Fw: Planning ref no. FG/100/19/HH Zac Denton
case officer

OBJECTION to proposed extension at 23 West Drive Ferring. BN 12 5QL.

Proposed Floor Plan

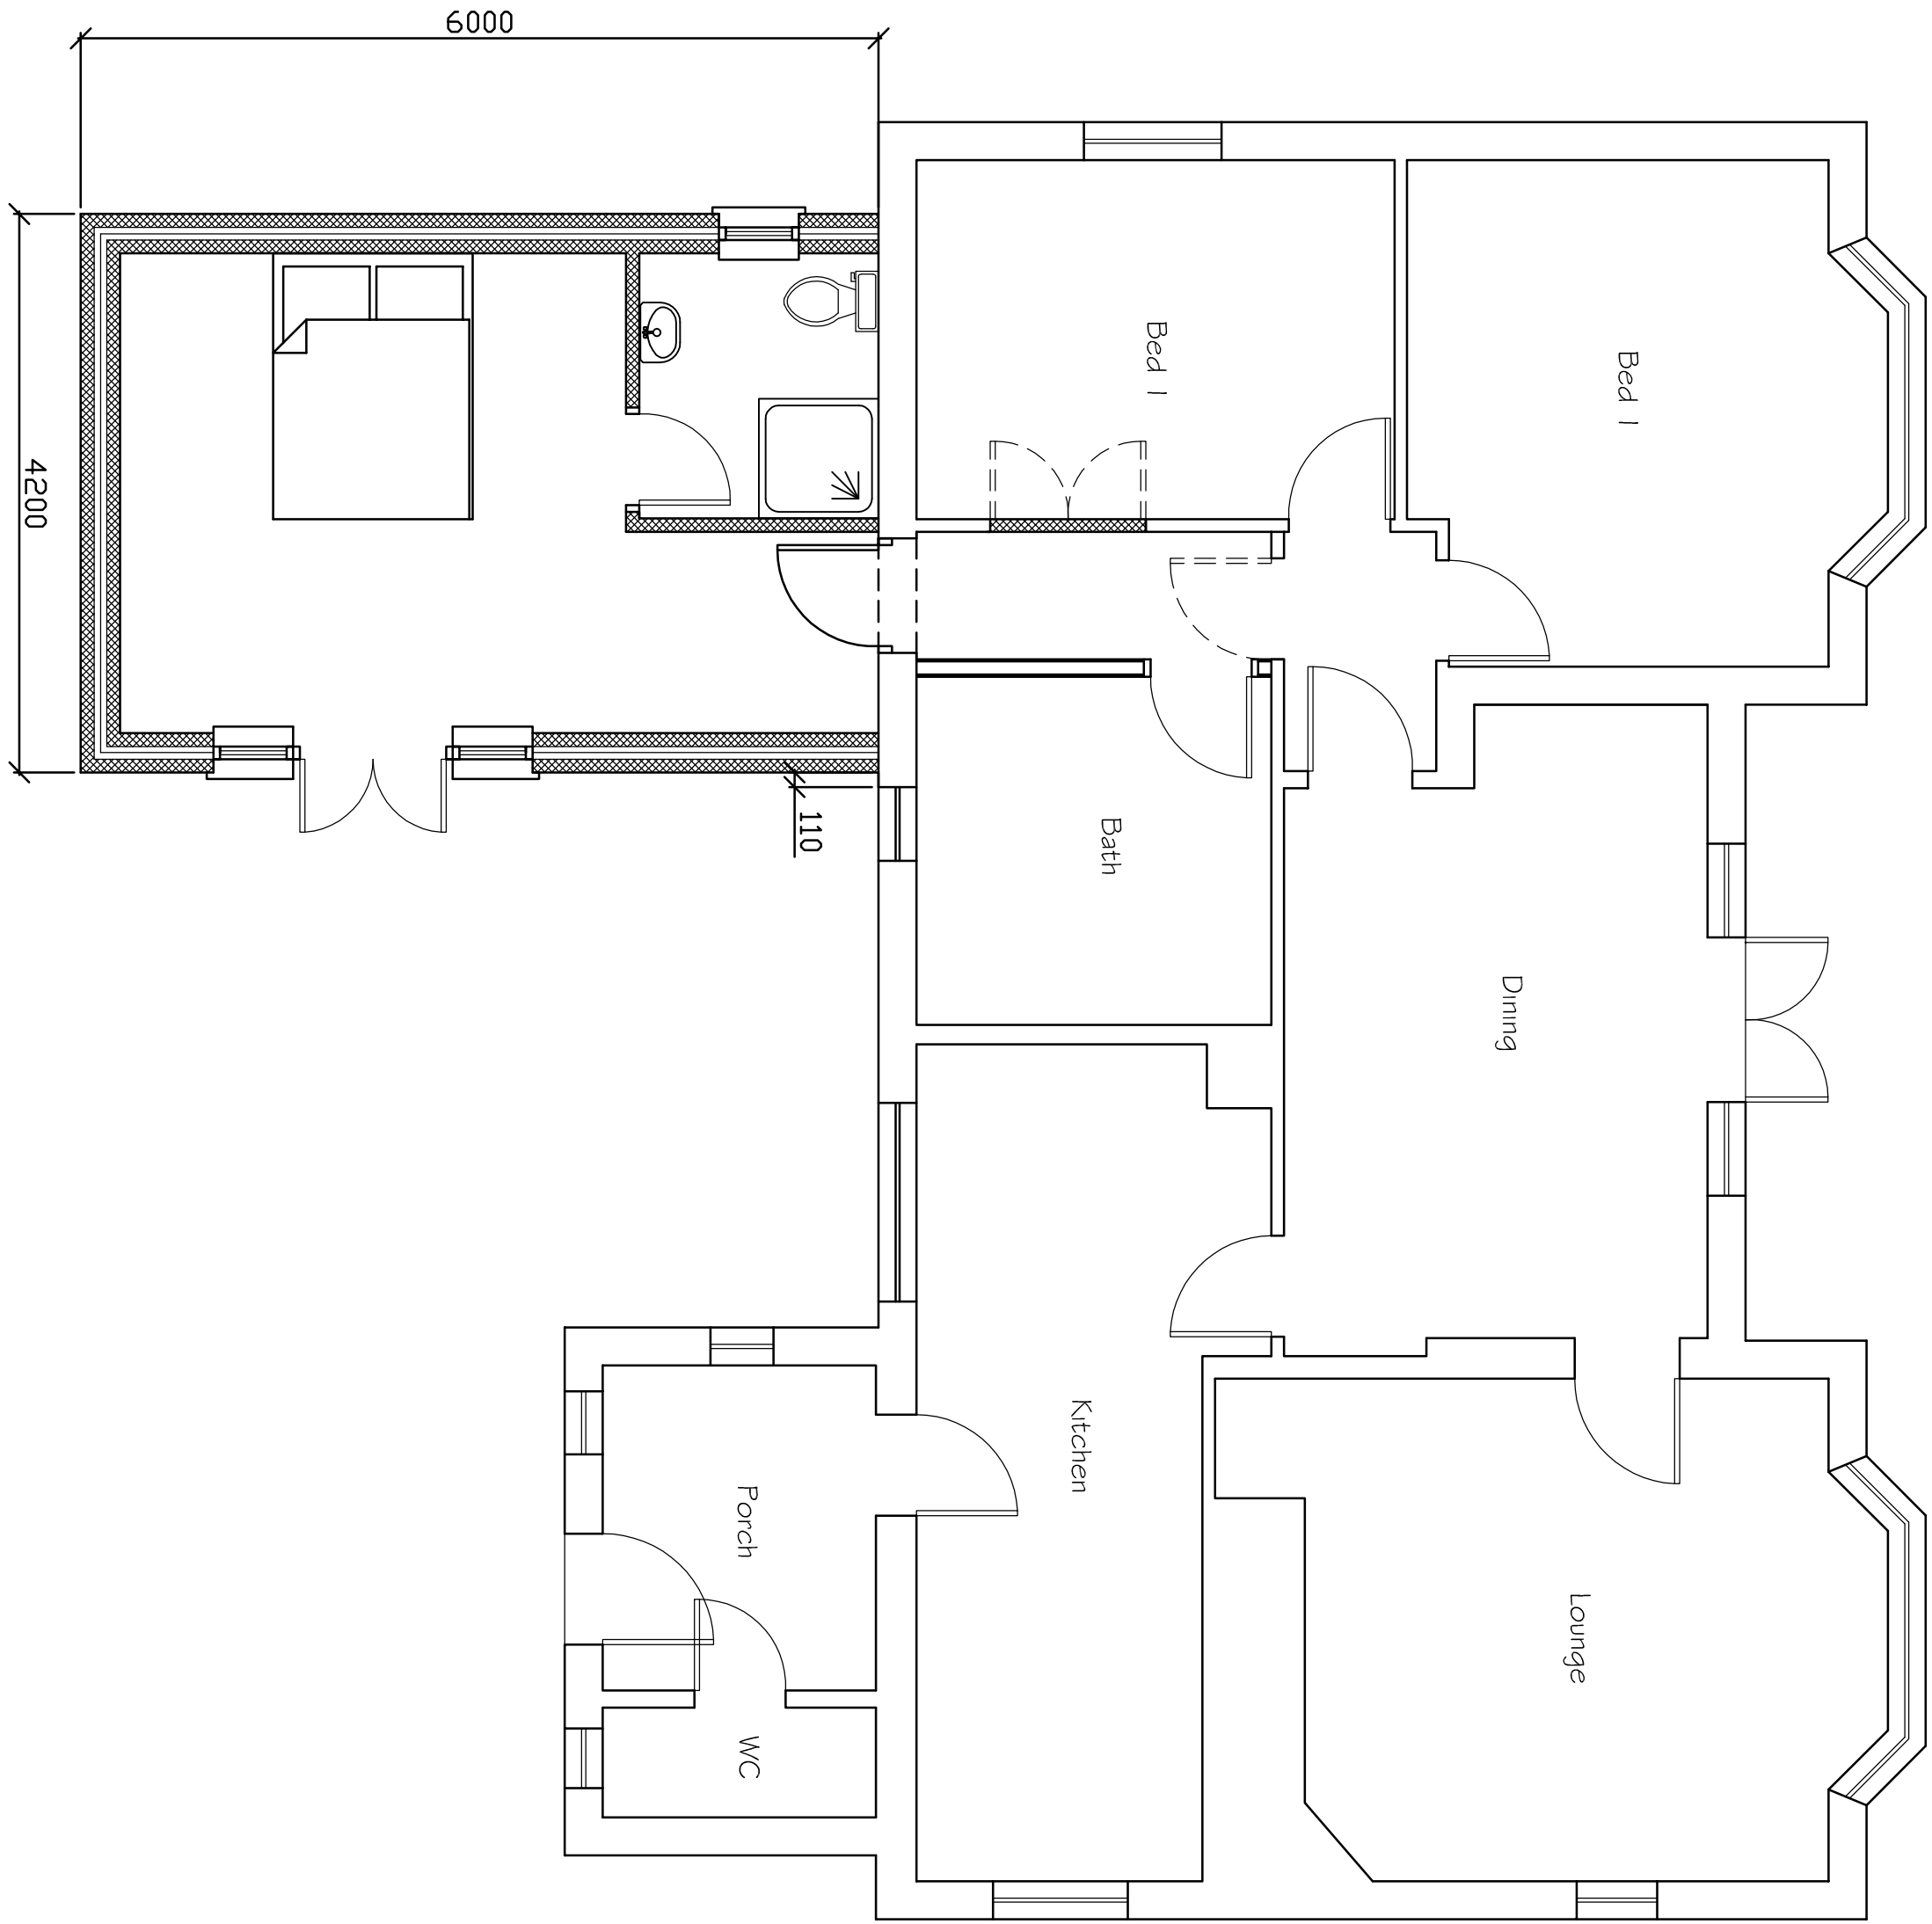
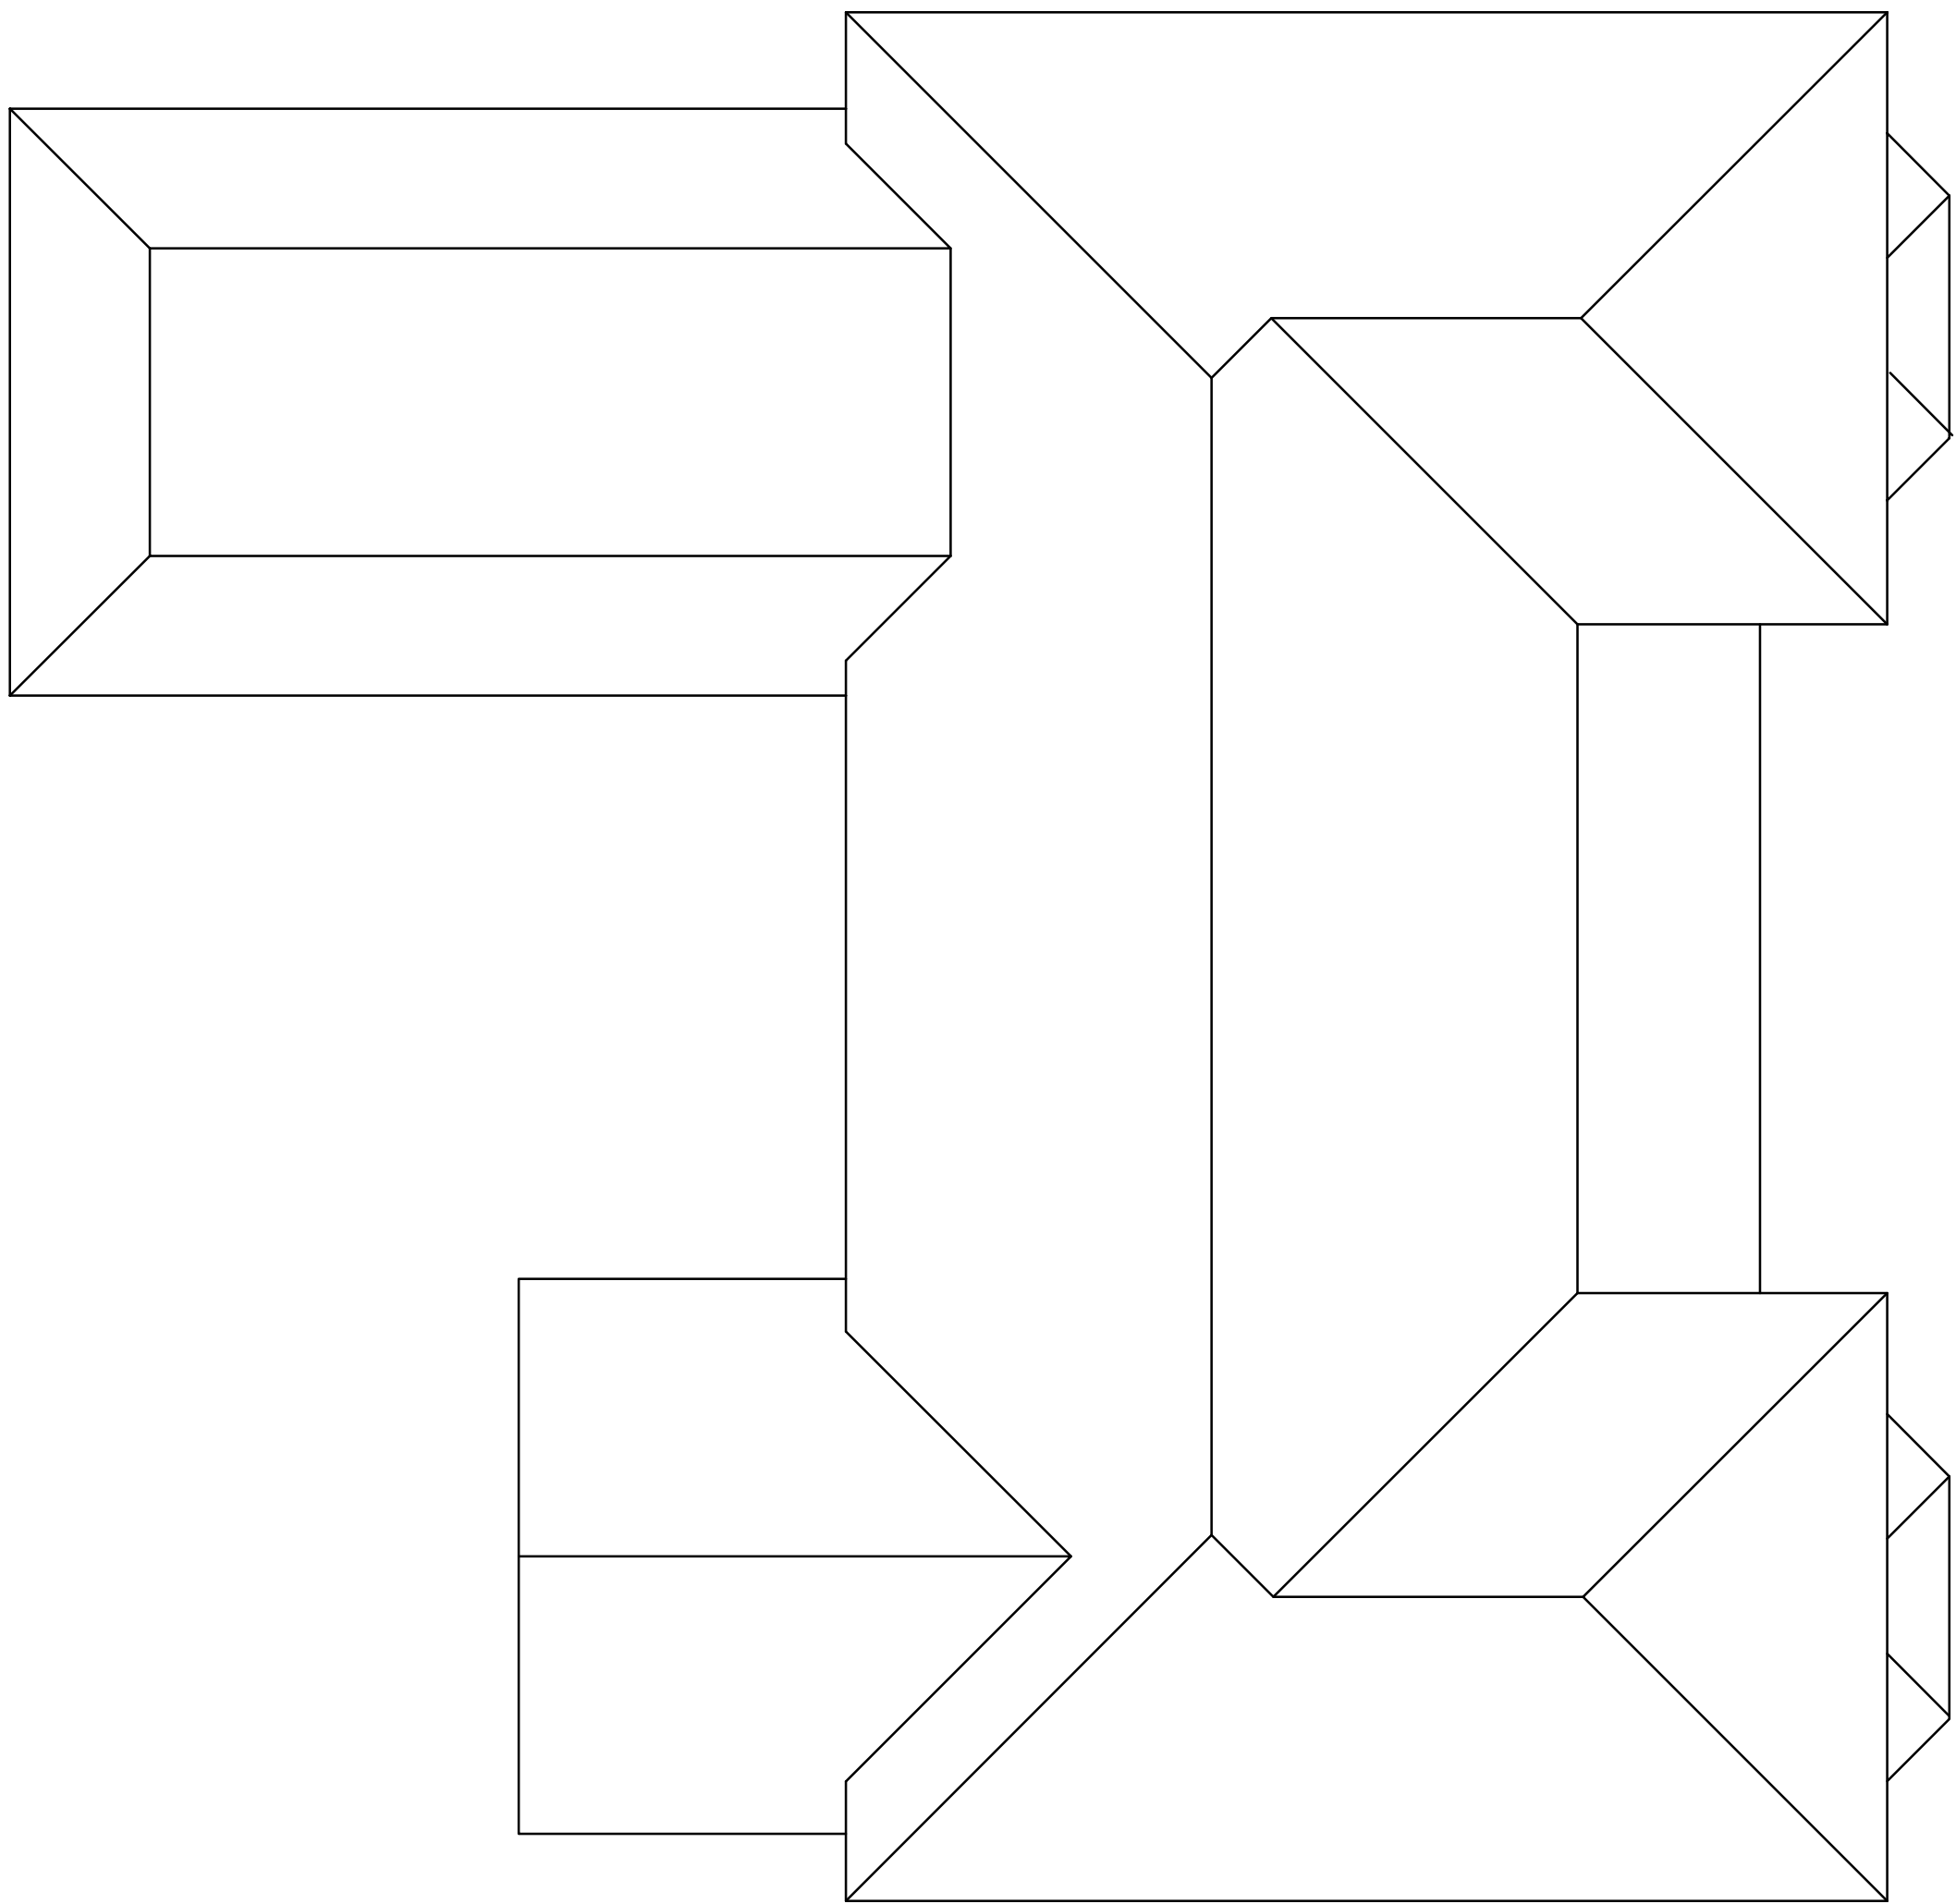
Also, I object to the proposed extension on the grounds that light in my bedroom and my lounge will be much reduced as my bedroom has glazed double doors facing south and my lounge has glazed double doors and a window that would both face an 11 - 12 ft high wall and roof of the proposed addition to 23. The mass of the new building is an infringement of the 45 degree rule.

The fact that the extension is to be positioned on the front elevation of the existing property as referred to by the architect is rather perverse when there is ample space to accommodate an extension to the rear of the house. There it would not affect my environment and my human right to enjoy home and garden in the future.

Finally, I would also be concerned that the proposed en-suite would require an extractor fan and I am unhappy that this would cause ongoing disturbance while I enjoy my garden
